April 14, 2015

Project Name: Century Tire Plaza  
Address: 195 Kennebec Street, Portland, ME  
Project ID: 2015-027  
CBL: 34-C-9  
Applicant: Northland Enterprises, LLC  
Planner: Nell Donaldson

On April 14, 2015, the Planning Authority approved with conditions a Level II site plan for the redevelopment of the Century Tire site at 195 Kennebec Street. The decision is based upon the application as submitted by Northland Enterprises, LLC and prepared by FST, Inc., with plan revisions dated April 1, 2015. The proposal was reviewed for conformance with the standards of the City of Portland's site plan ordinance, Article V of the land use code. It should be noted that the plans for the project's Marginal Way and Kennebec Street frontages were found to meet the guidelines of the Marginal Way Master Plan and the Somerset Street Extension Feasibility Study respectively, and that the provision of the sidewalk along the property's eastern boundary was found to meet the city's B-7 and site plan standards related to street connectivity and safe access for all site users. The Level II site plan is approved with the following waivers and conditions:

PRELIMINARY - NOT FOR CONSTRUCTION

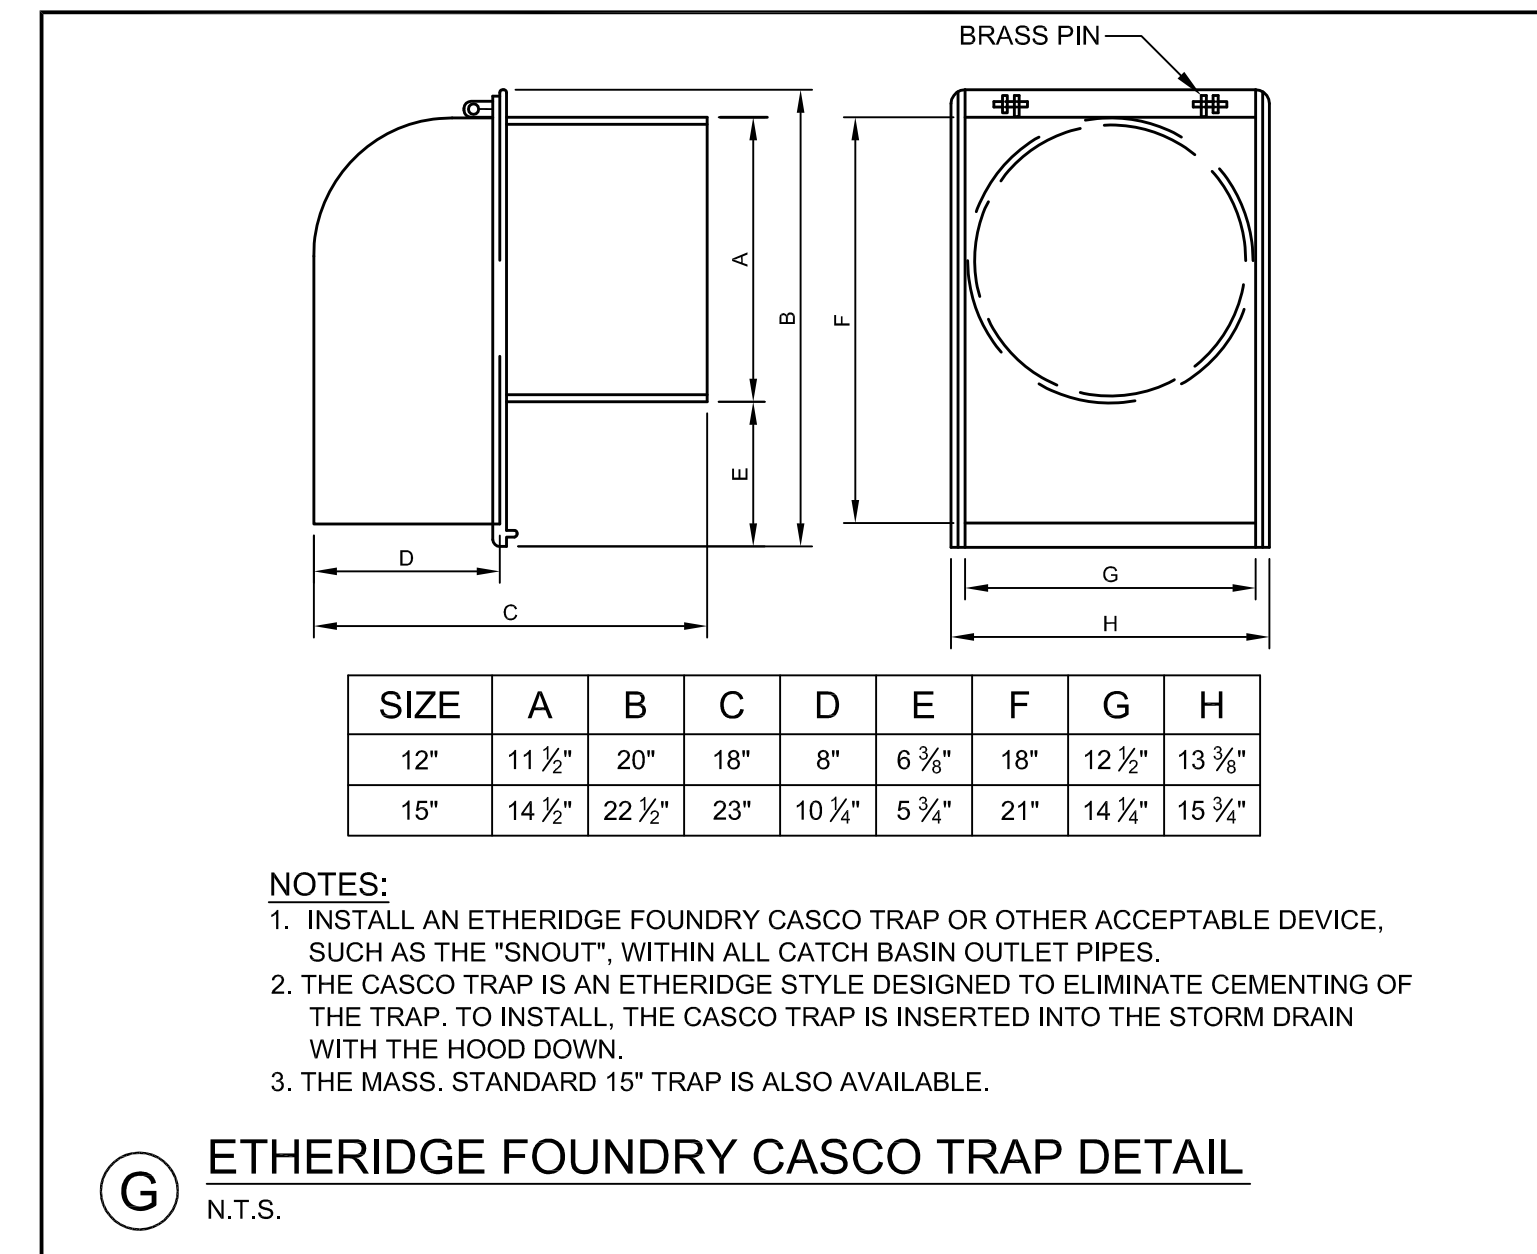
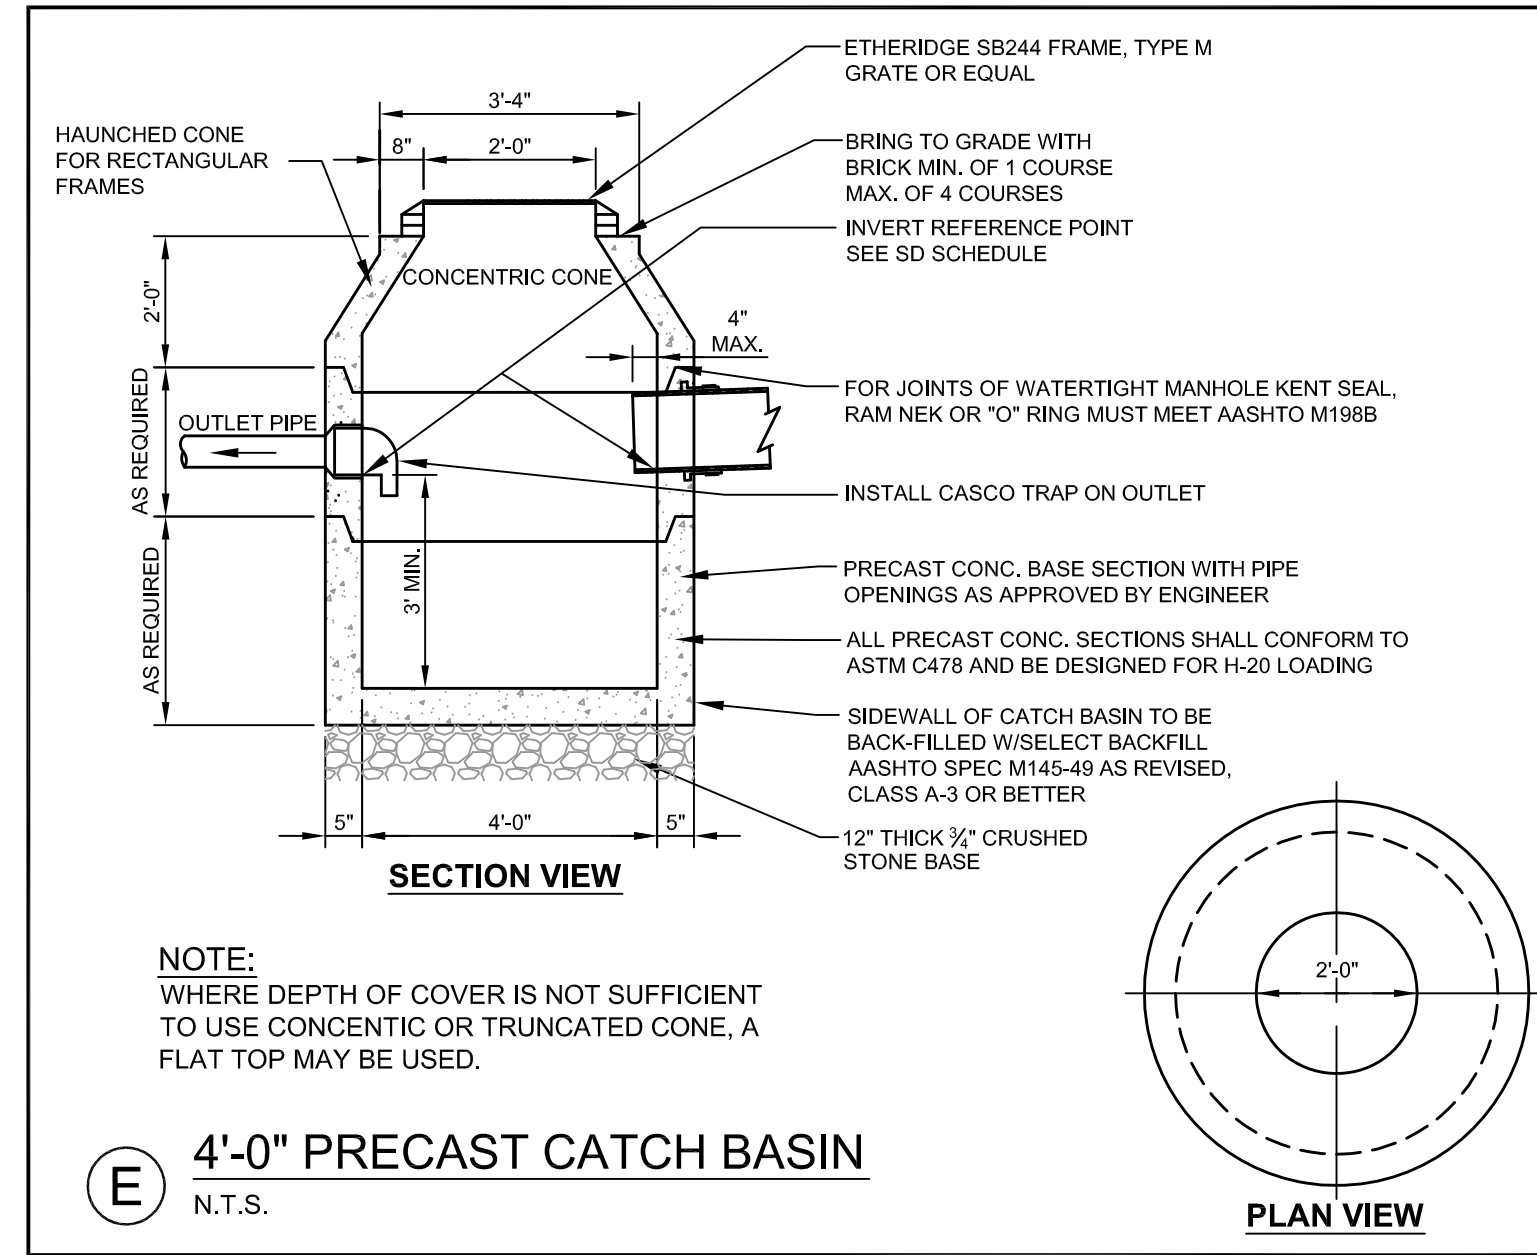
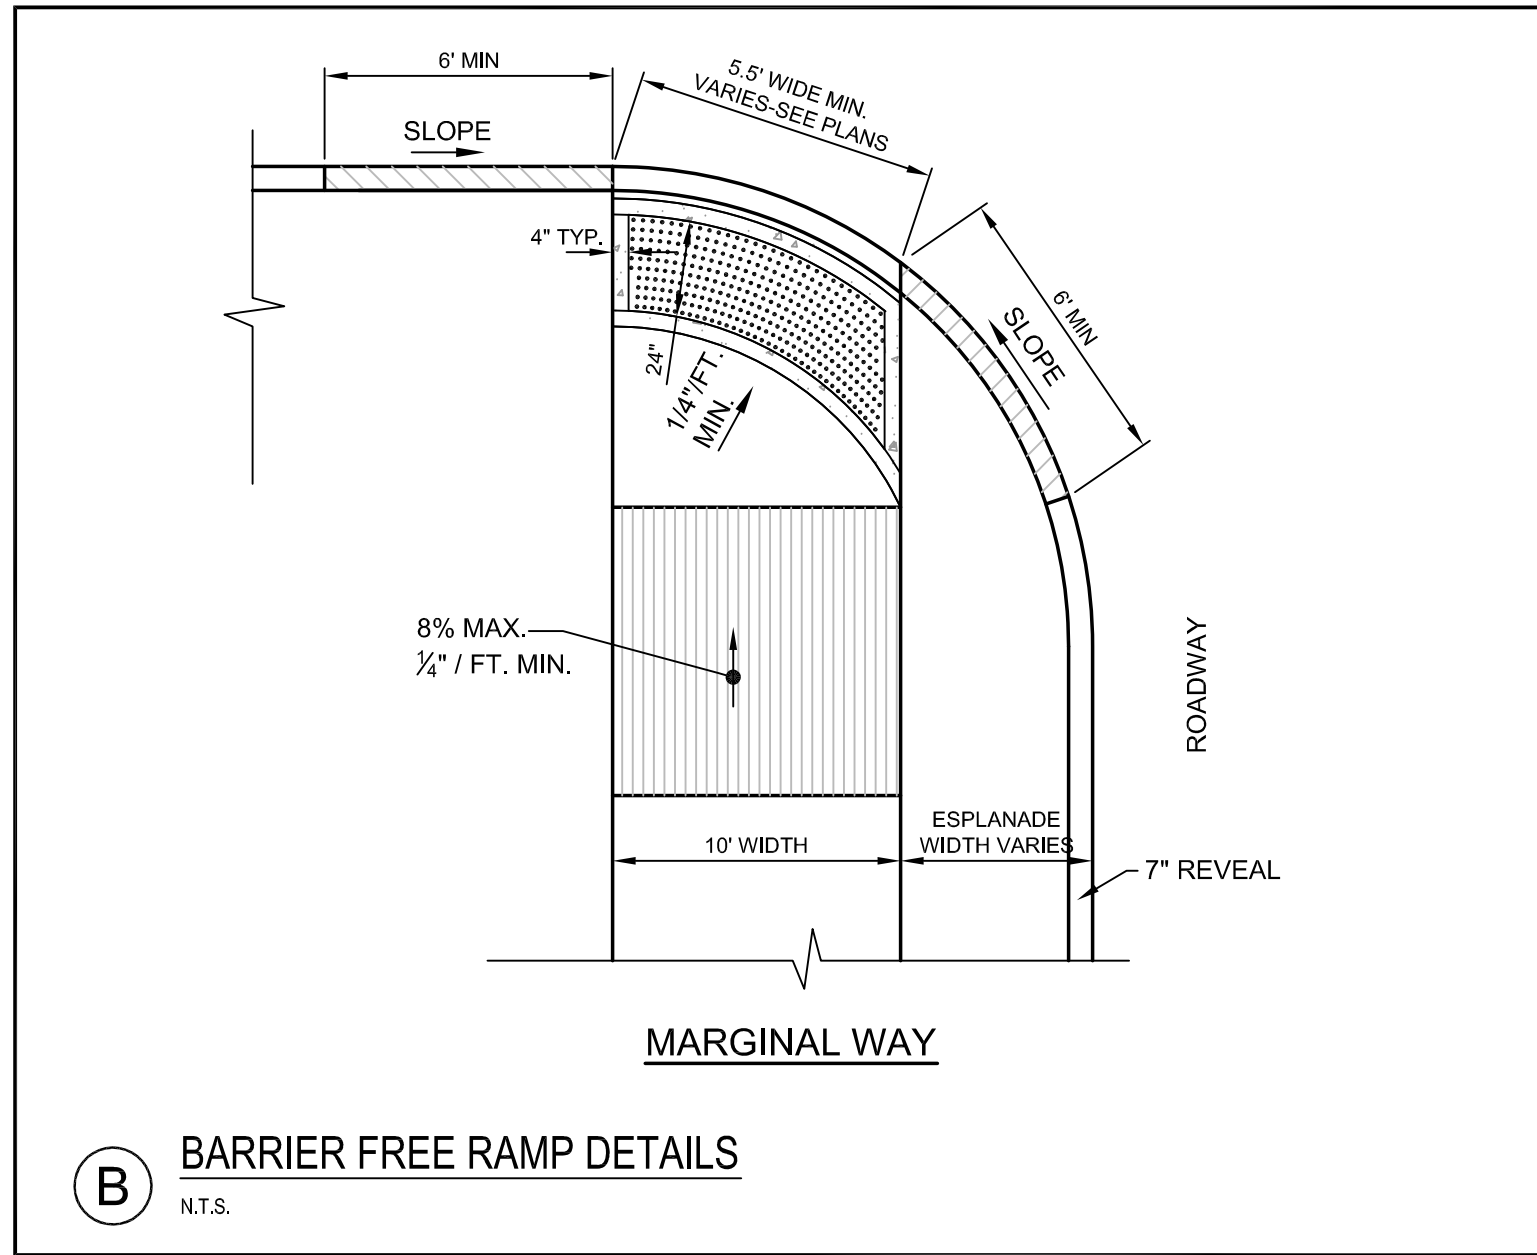
Detail A on plan sheet C-7.1 shows a curb reveal of 6 inches along Kennebec Street. The City standard for curb reveal is typically 7 inches. The curb reveal should be changed to match the City standard unless there are over-riding considerations that require a 6 inch curb reveal. A change to 6 inch curb reveal may require changing the specification for granite curb terminal pieces from 6 feet to 7 feet in length.

6. The applicant shall revise details to depict the city's standards for curb reveal and depth of base gravel for a brick sidewalk on bituminous base for review and approval by the Department of Public Services;

FST FAY, SPOFFORD & THORNDIKE ENGINEERS • PLANNERS • SCIENTISTS 778 MAIN ST., SUITE 8, SOUTH PORTLAND, ME 04106	
DRAWN: DED	DATE: 11.25.14
DESIGNED: ADJ	SCALE: 1" = 20'
CHECKED: ADJ	JOB NO. SP-M160
FILE NAME: SP-M160 BASE	
SHEET	C-5.0

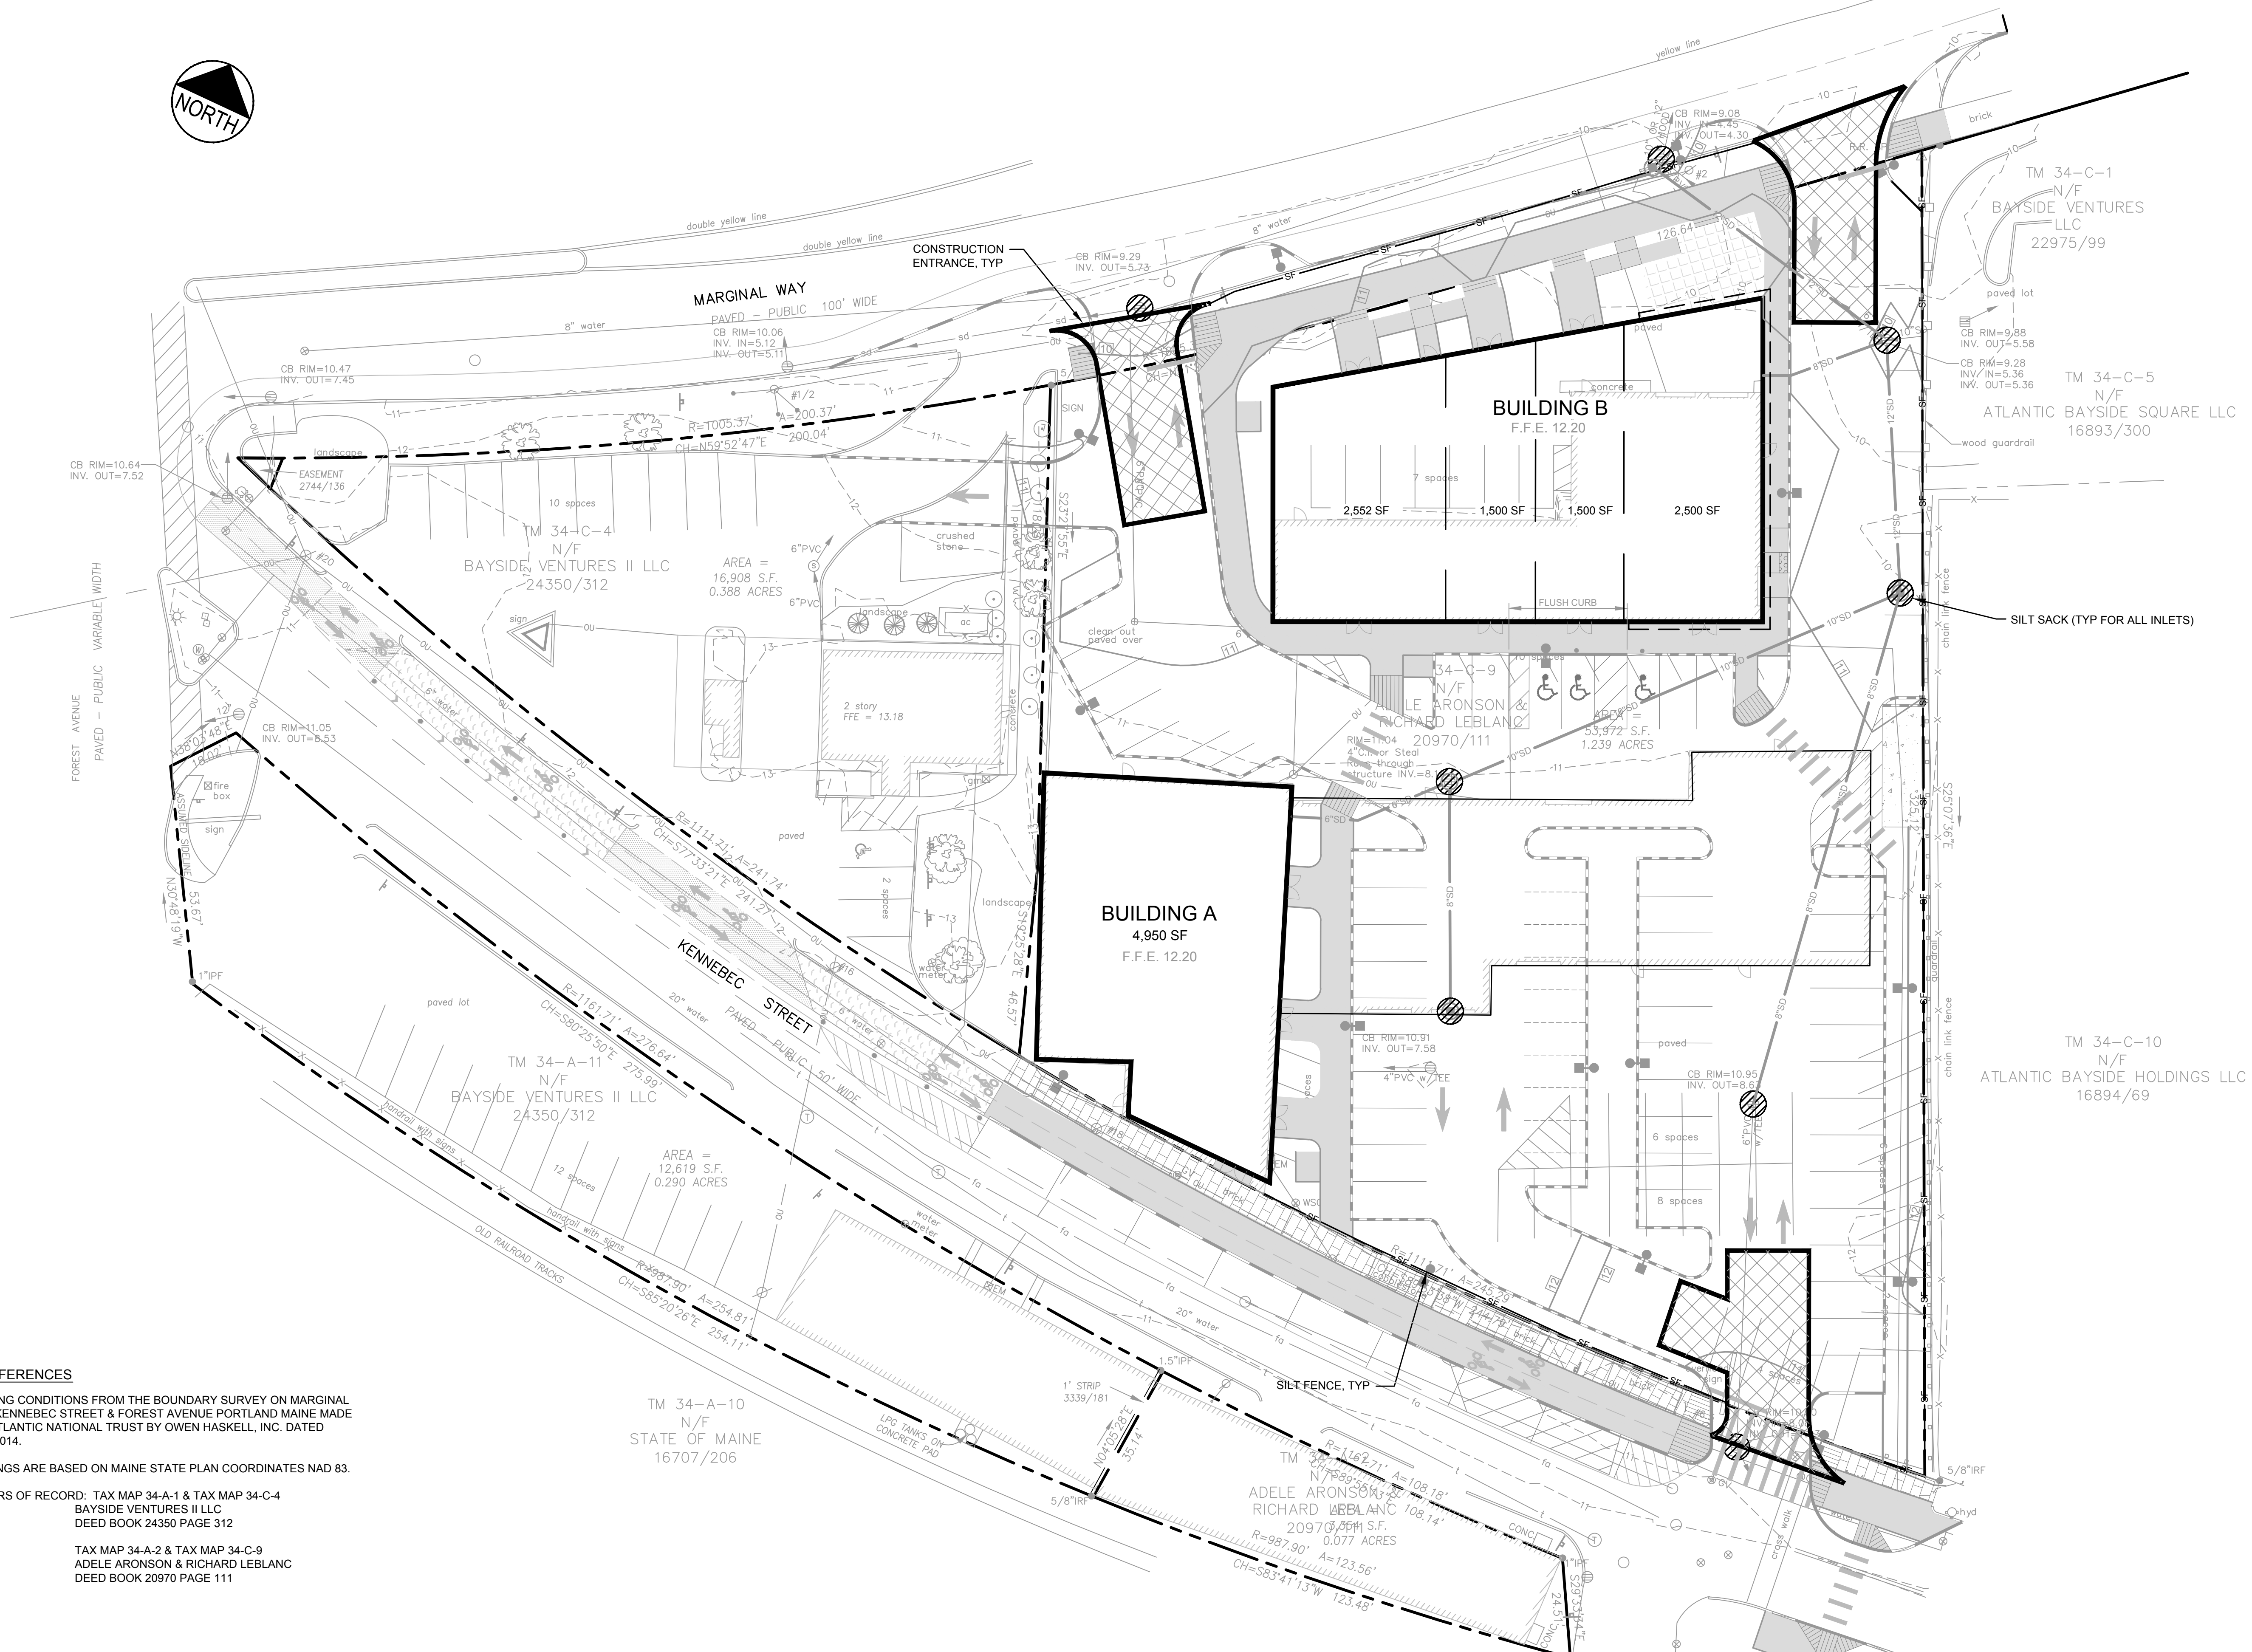
- Revise Sheet C-5.0 to include erosion and sediment control practices as submitted in the original plan setfor review and approval by the Department of Public Services;
